Application No: EP/7/21/HH
Site Address: Little Dormers 23 Upper Drive East Preston BN16 1QN
Description of works: New bay/porch skirt roof to front elevation & single storey front extension to provide additional garaging.

Thank you for your internet representation made on 28th February 2021 which has been recorded as an objection with the comments as follows:

South Elevation –
(Side) 1:100

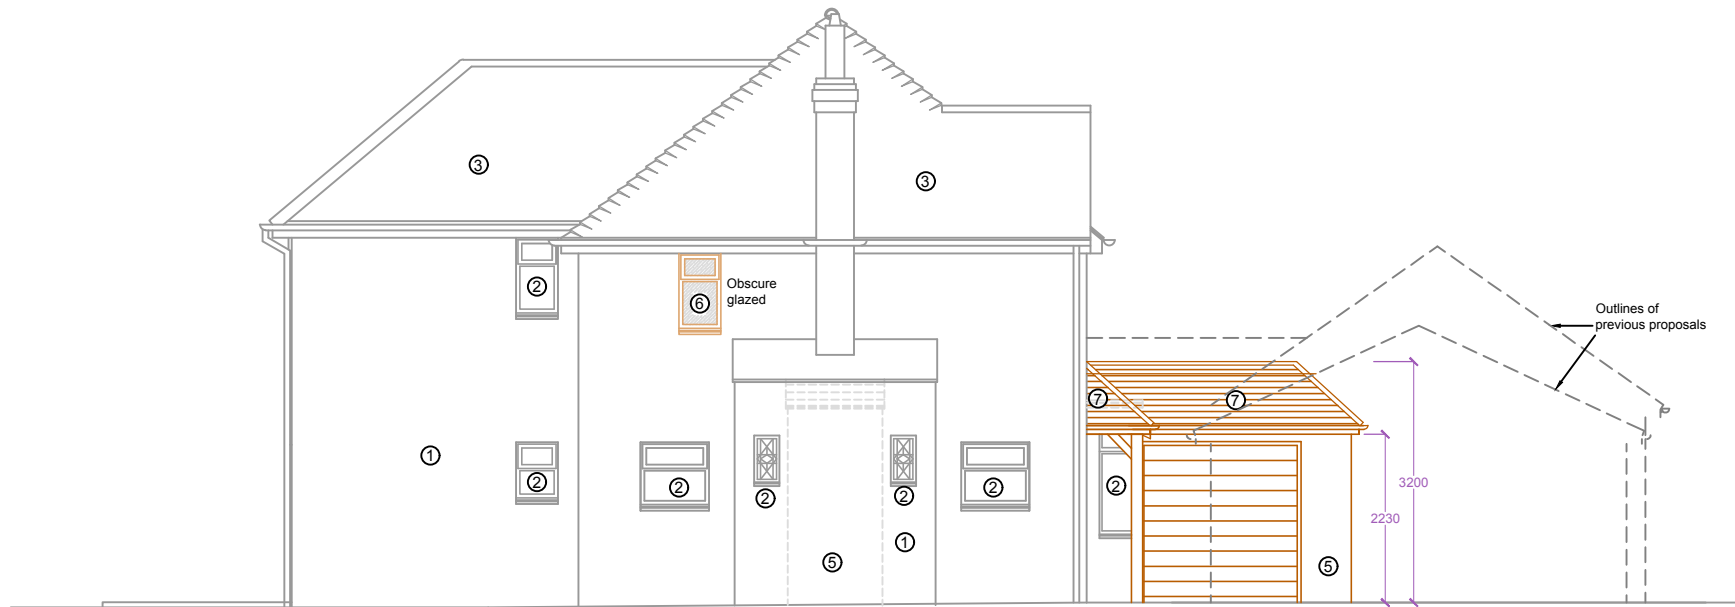
This third application shows new upstairs windows on the south and west of the property. These look directly into the neighbours' gardens and into their homes taking away their right to privacy. Please can you ensure that IF the placement of these windows is authorised, they should be non-opening and have obscured glass. Some helpful and neighbourly suggestions for alternatives have been made by Mr Flanders which would give the applicants more light (velux windows) and look more balanced from outside.
